SLR Reference: 403.064816.00001
KC planning application reference: 2019/93658

RE: *Whitechapel Road, Cleckheaton*
Response to Formal Consultation Comments, Air Quality Considerations to Variation of Conditions

FOR SECTION PLEASE REFER TO
JRP DRAWING:
P17:5076:10 D

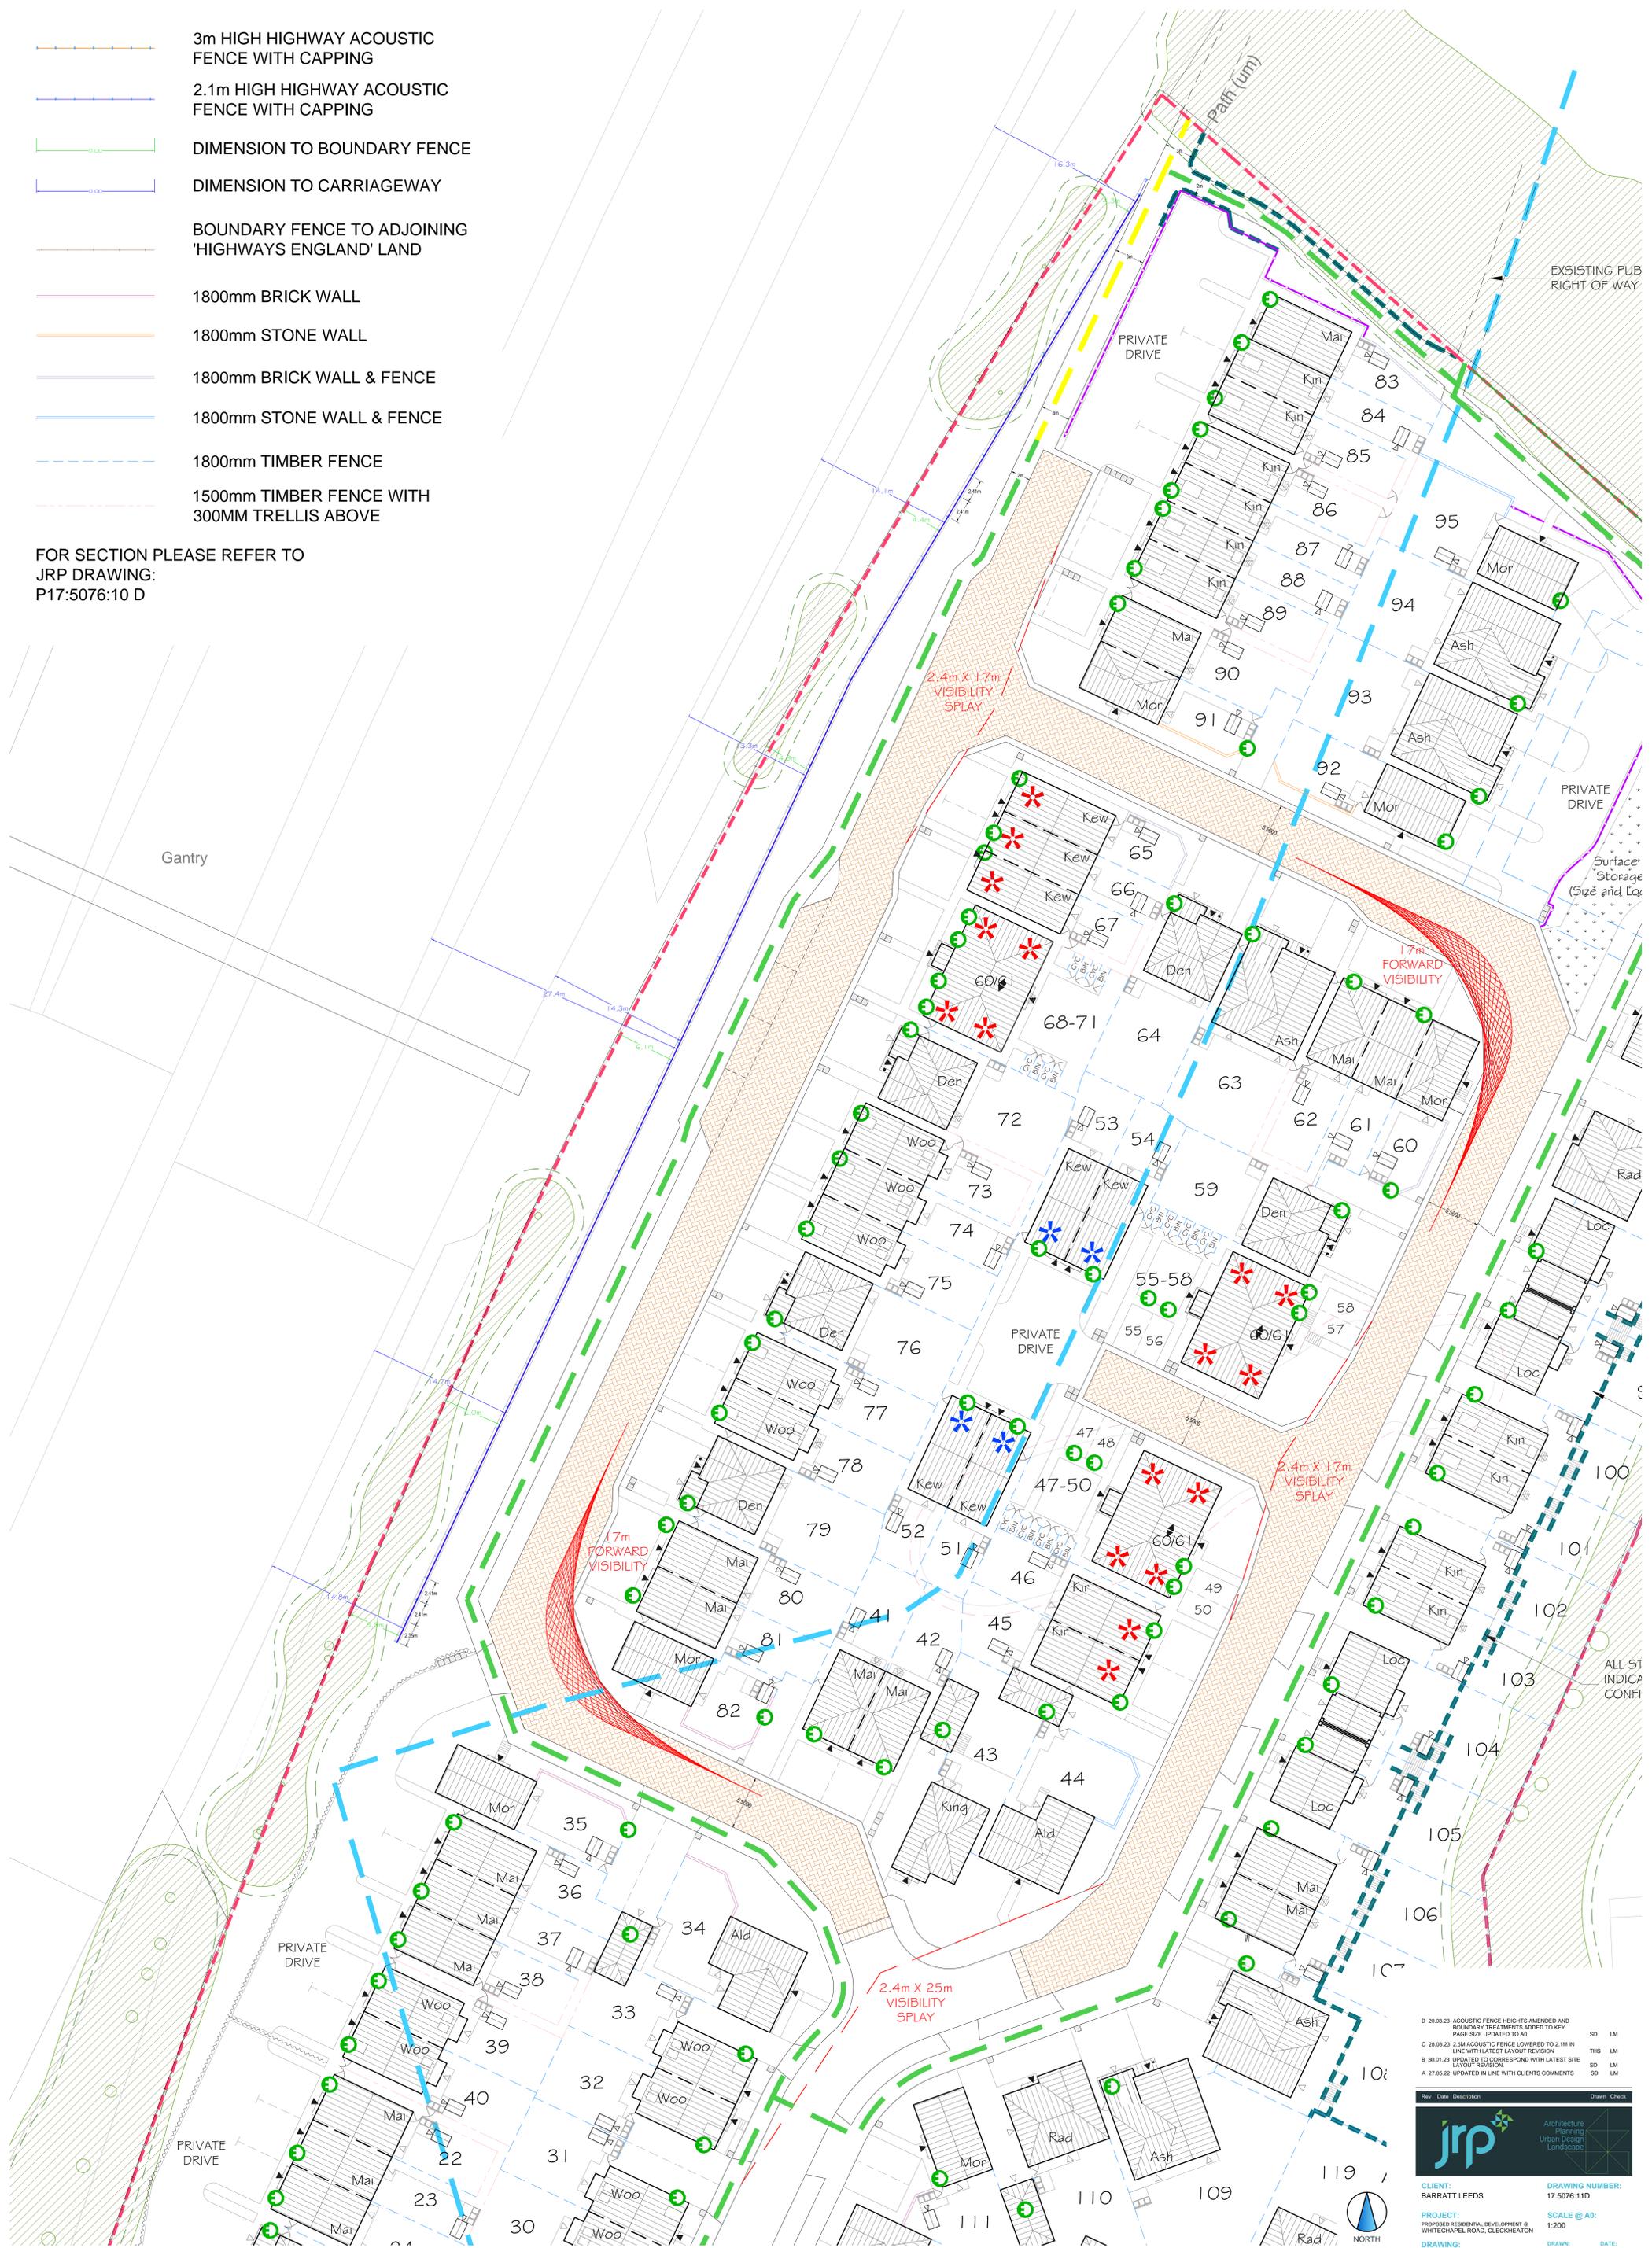
No information has been submitted to support these findings. Revision ii dated 12.03.21 of the Proposed Site Layout Ref:P17:5076:01 states 'Proposed bund adjacent motorway added'. There are no further revisions pertaining to the removal of the bund.

Therefore, the results and conclusions to the *Air Quality Assessment: Noise Barrier Modelling and Analysis*² report in terms of the identified beneficial effects afforded by the 2.1m high acoustic fence / structure, and the identified 2.75m reduction in the required buffer zone / separation distance remain valid and correct.
